## RESPONSE TO INFORMATION REQUEST

**COUNCIL REF: DA09/0701.03 LN35979**

**TSC SUBMISSION ALTITUDE ASPIRE RESIDENTIAL SUBDIVISION  
MP09/0166 MOD 3**

- 1 ENTRY PRECINCT
- 2 COMMUNITY PARK NODE
- 3 POCKET PARK
- 4 WETLAND RESERVE
- 5 CREEK / DRAINAGE CORRIDOR
- 6 FRASER DRIVE ENTRY

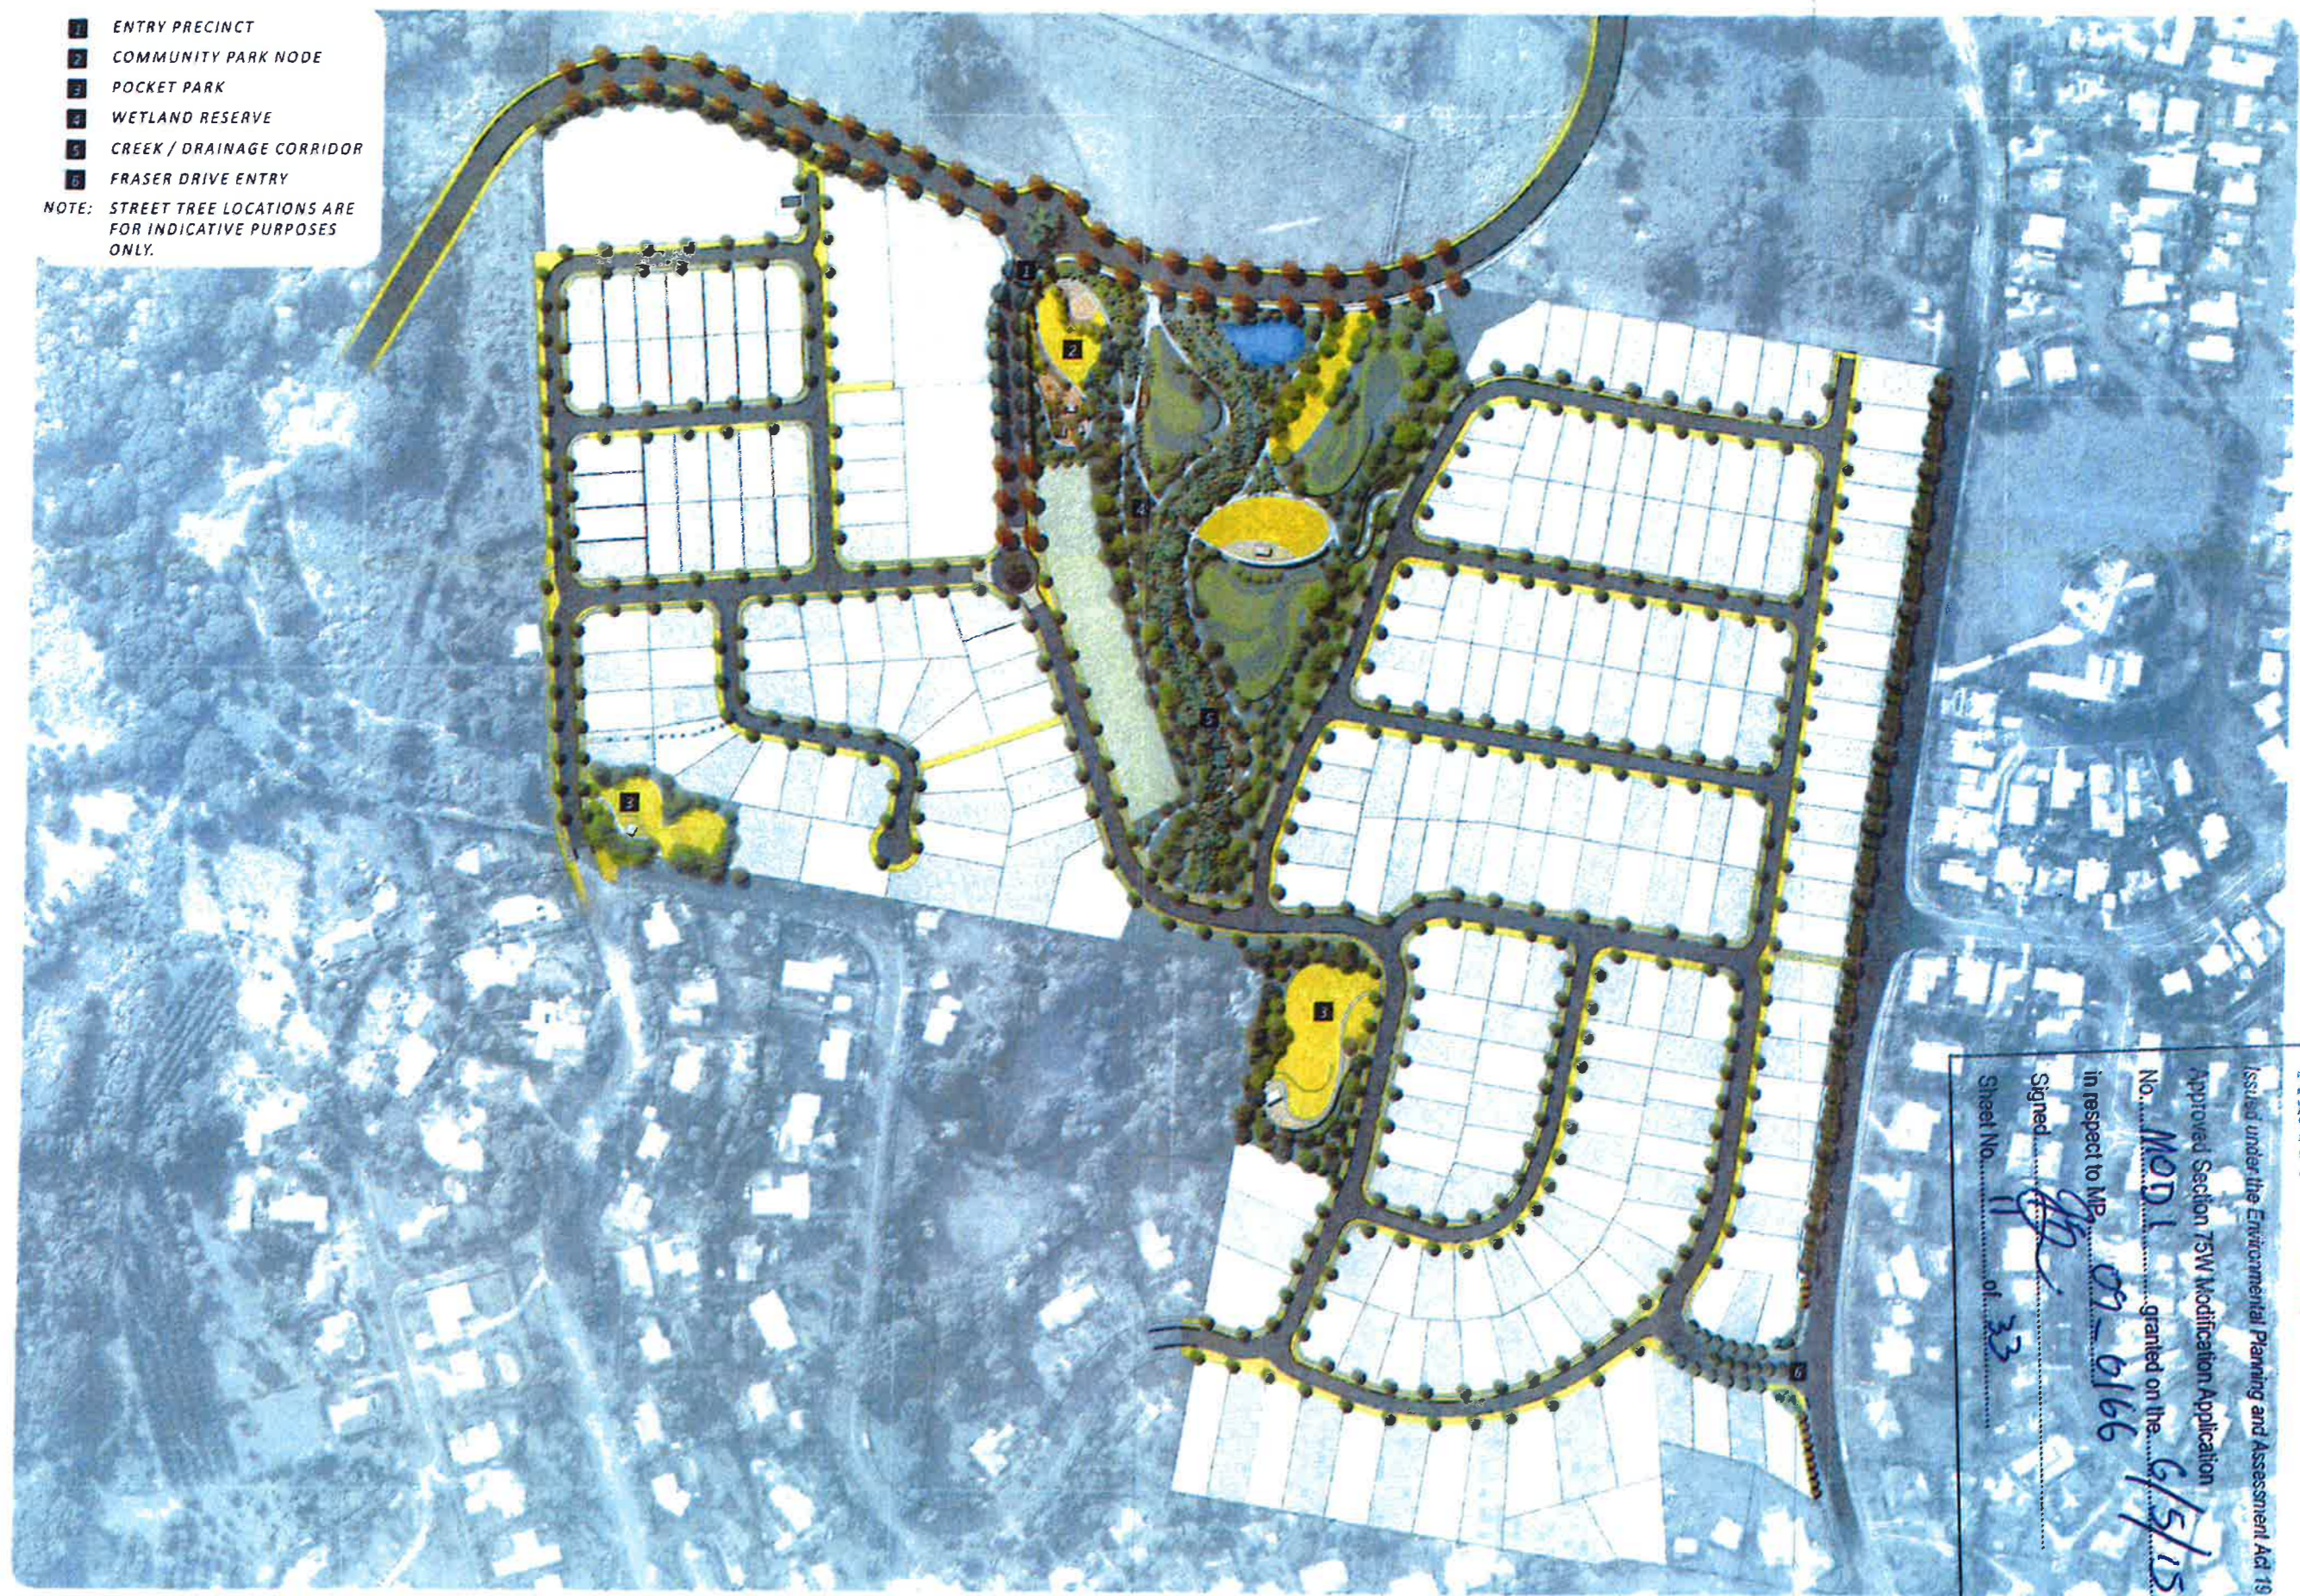
*f. Sheet 3: the frontages of the following lots have been overlooked for street frontage treatment (tree planting): Lot 1112 fronting Market Parade; Lots 501 and 502 fronting Parkes Lane.*

An indicative street tree and new turf has been added to these two lots.

NEWLAND DEVELOPERS PTY LTD	
TERRANORA PRECINCT 1 CENTRAL OPEN DRAIN SWALE PLAN	
09-374 21.09-2017	SK3618 REVISION E

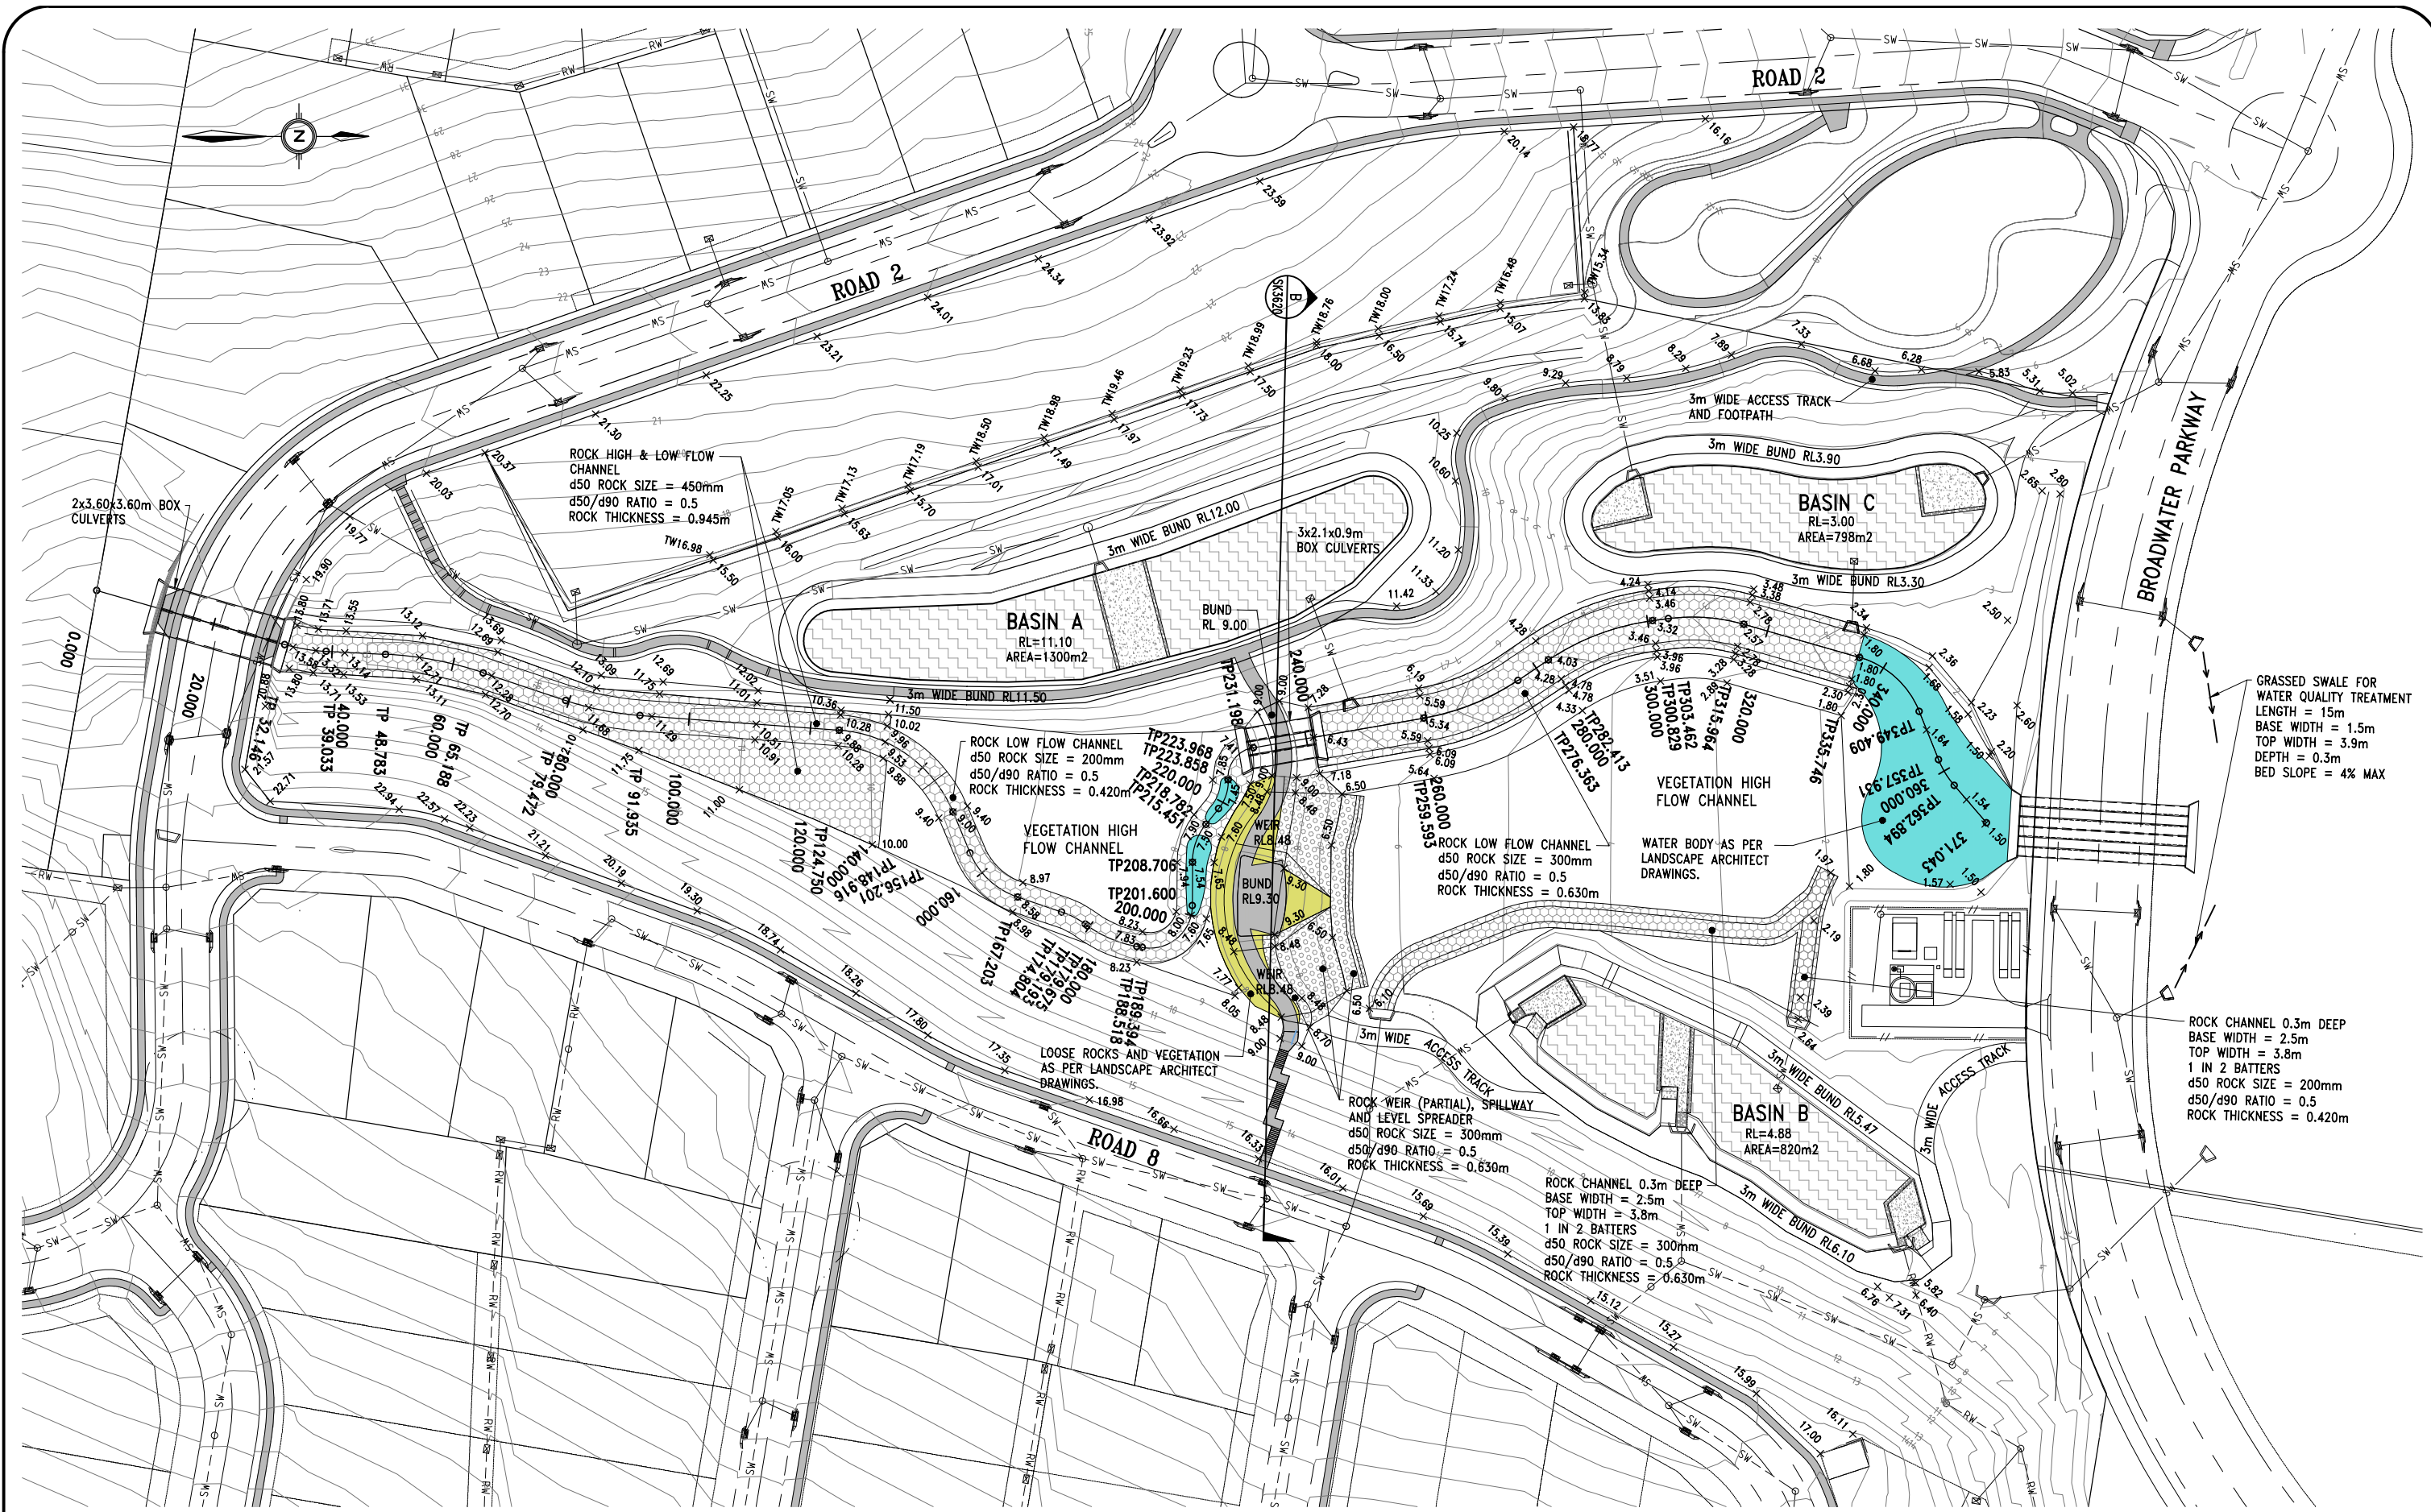
*h. Sheet 5: the eastern side of the Drainage Reserve now depicts a 'straight' access path up the batter slope to Ossa Blvd, whereas the existing approved plans show an angled path. This appears to have created a scenario for stairs up this batter slope – as depicted on plan SK 3618 Rev.E (Annexure 'H'). The preferred option would be for a ramped access to avoid stairs. The applicant is requested to demonstrate why stairs are proposed in lieu of a ramp.*

*i. Similarly, access to the Drainage Reserve from the south end appears to incorporate stairs and scattered steps, as depicted on Bradlees plan SK 3618 Rev.E. Stairs are to be avoided wherever possible and the applicant is requested to demonstrate an access option without stairs, if at all feasible.*

As mentioned under Item D.v.a ramp was considered however the extent on additional retaining walls and earthworks required to make the ramp DDA compliant was cost prohibitive and would also impact the hydraulic models through the drainage reserve. Retaining walls are also supposed to be prohibited within the drainage reserve as per DCP 24.

Again, installing a ramp in this location is not feasible due to earthworks and retaining required to make the ramp DDA compliant and would also impact the hydraulic models through the drainage reserve. There is also civil infrastructure through this area that paths need to stay well above.
